DECISION DELEGATED TO DEVELOPMENT MANAGER

Application No:	H16-0012-21	Applicant:	Centric New Homes Ltd.
Proposal:	Conversion of Existing 5 Bedroom Bungalow into 2no. Self Contained Flats		
Location:	2 Carrington Road Spalding		
Terminal Date:	3rd March 2021

Proposed Elevations

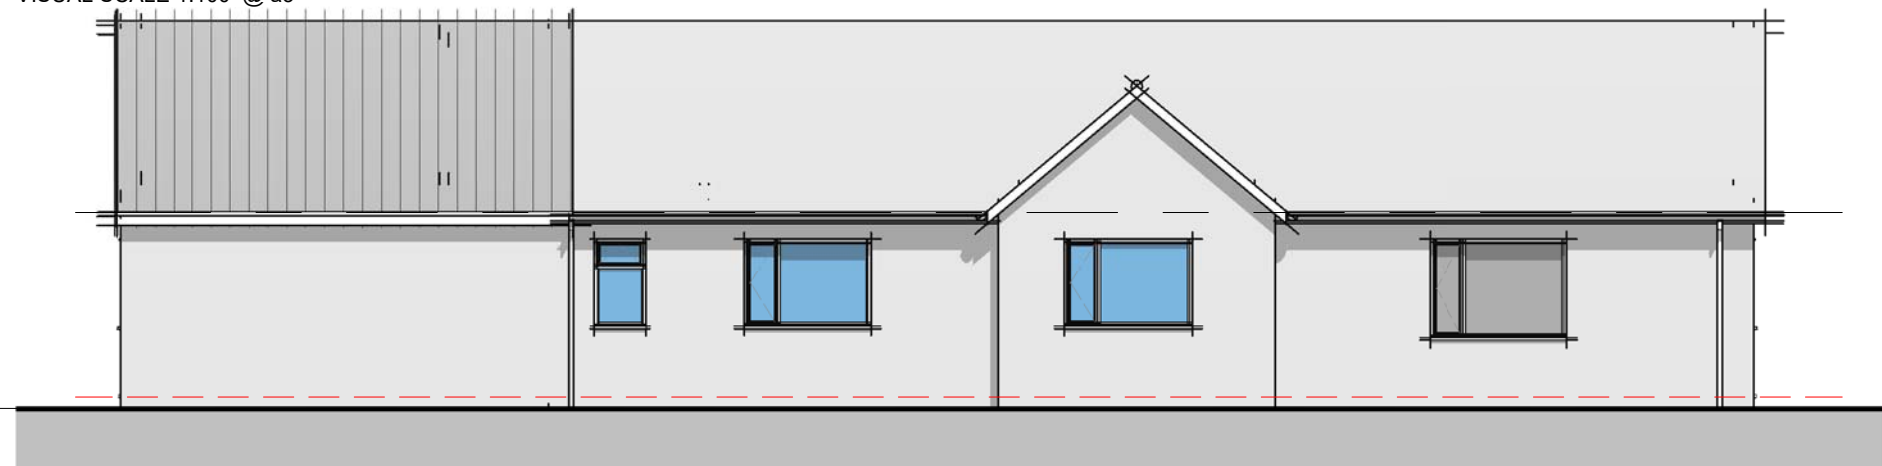
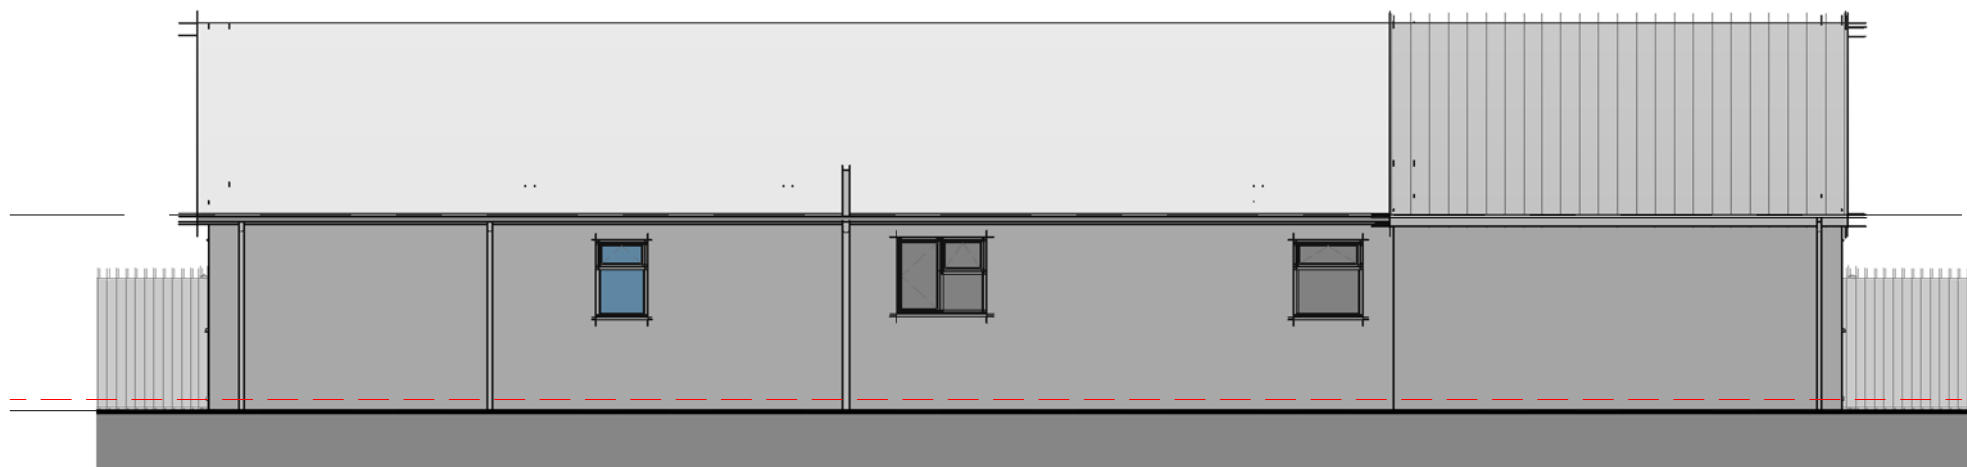
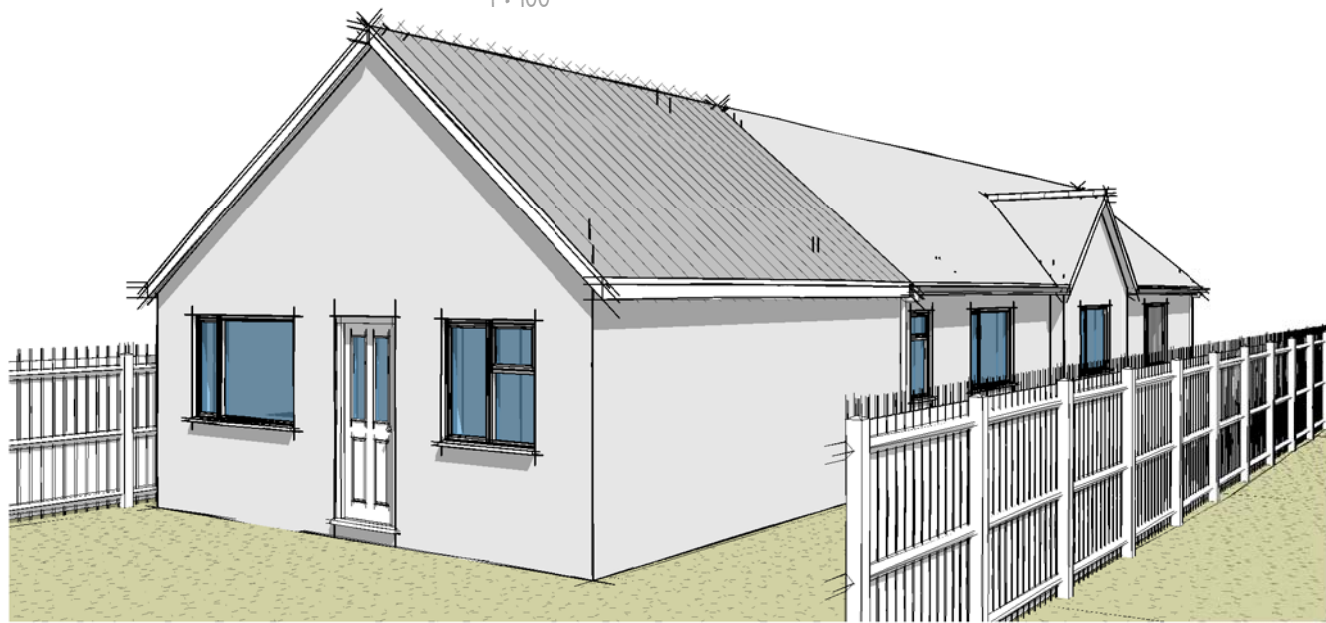
1. A sense of place is not considered to be materially impacted by the proposal. The bungalow is not being materially changed, and the surrounding area does not have a defined built character. indeed the proposed pitched roof to the front extension would be considered to improve the appearance of the property.

Proposed Floor Layout

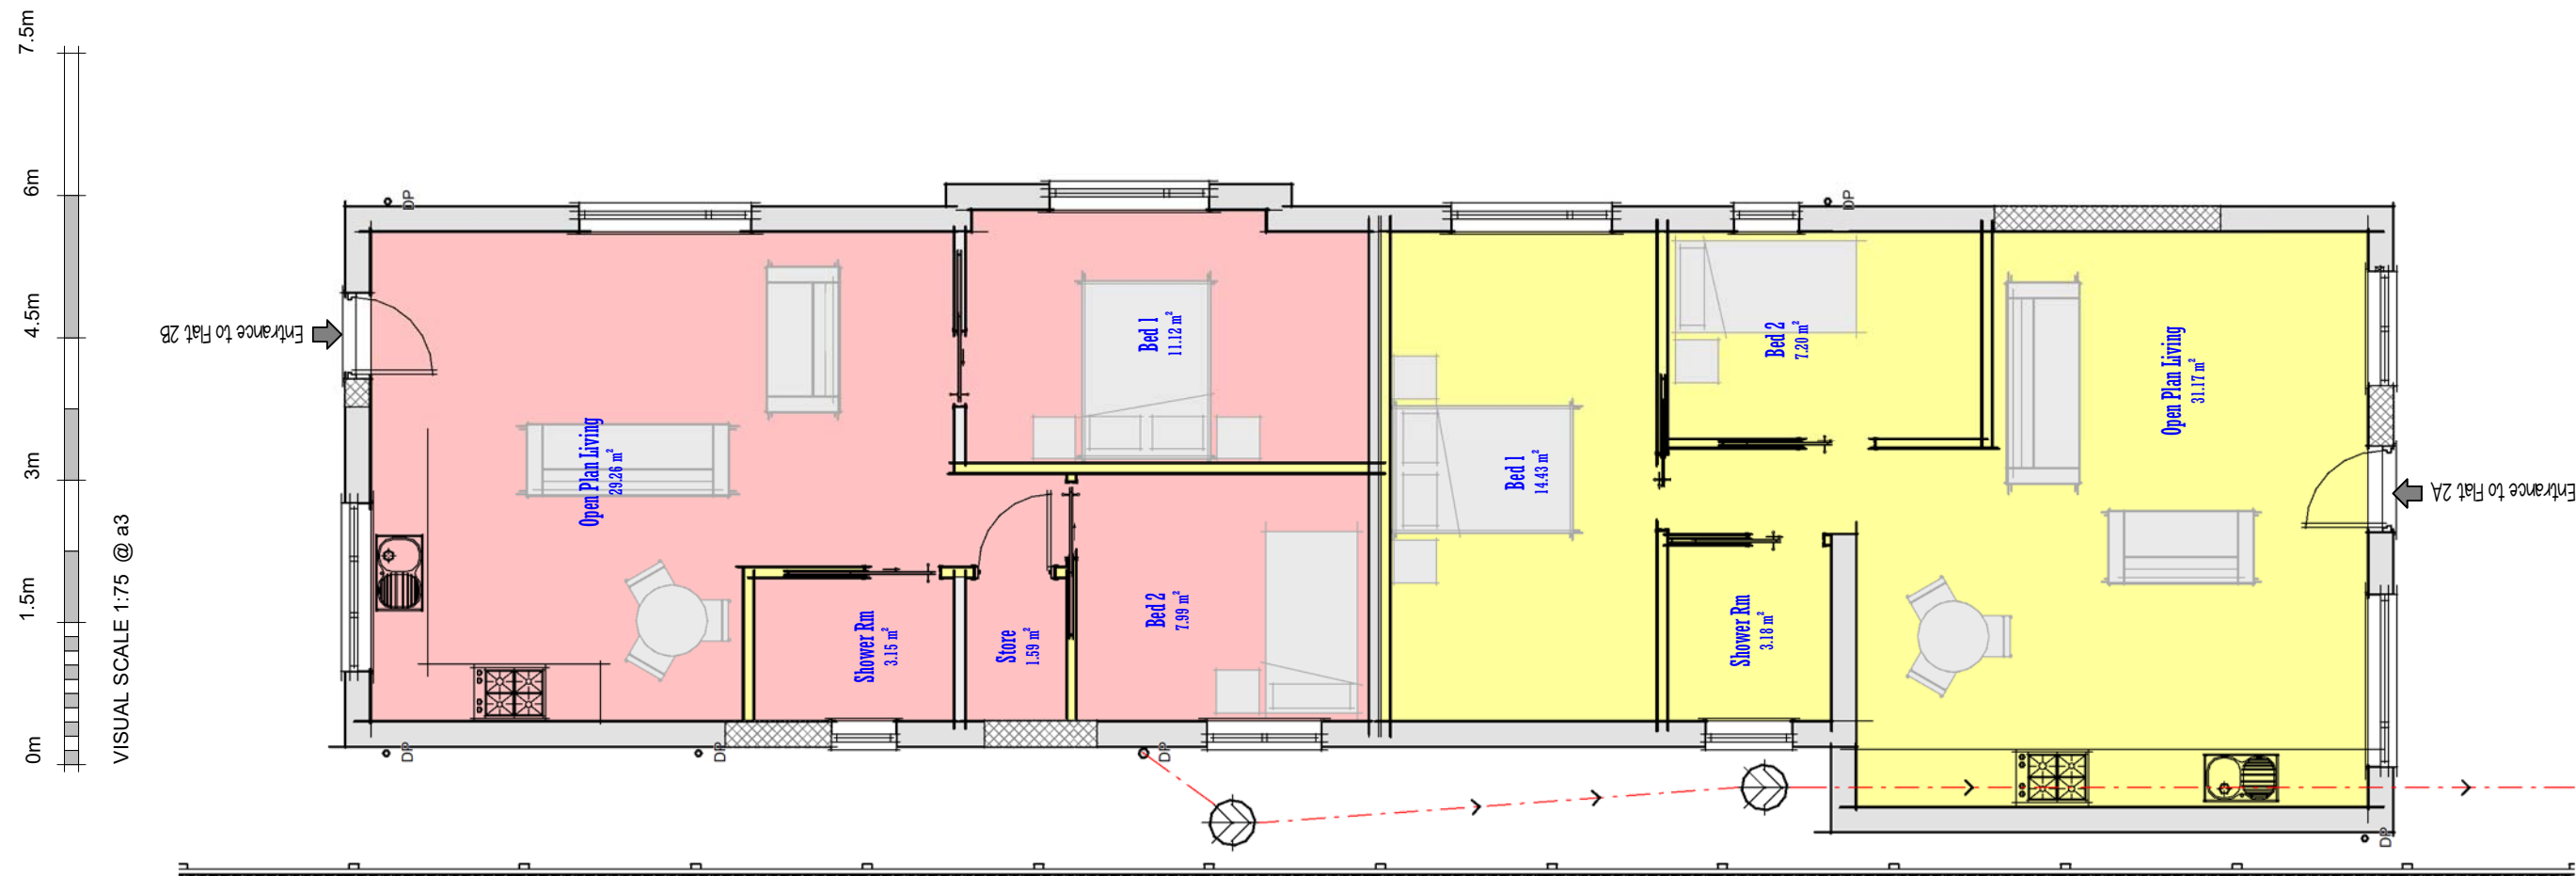
2. The design of the parking provision is cramped and amenity space is small for Flat 2a, and none is provided for Flat 2b. The orientation of the site cannot be altered as the bungalow is already in existence.

5. Each dwelling has two bedrooms and a single parking space. Therefore the proposal would likely lead to an increase in on-street parking, impaired highway safety through reduced visibility and increased traffic, and impeding proper access by Flat 2b and the dwelling approved under H16-0960-18 being served by a single vehicle width driveway.

8. Flat 2a has amenity space to the front that measures a maximum of 5 metres in length and 4 metres in width if no boundary treatment is provided. Flat 2b has no external amenity space taking into account the positioning of the proposed parking space.

Each flat has two bedrooms, therefore a minimum of two off-road parking spaces are required. The provisions of Appendix 6 of the Local Plan were highlighted to the agent and an amended block plan was received on 12 February 2021. However, this still only indicates a single parking space for each property.
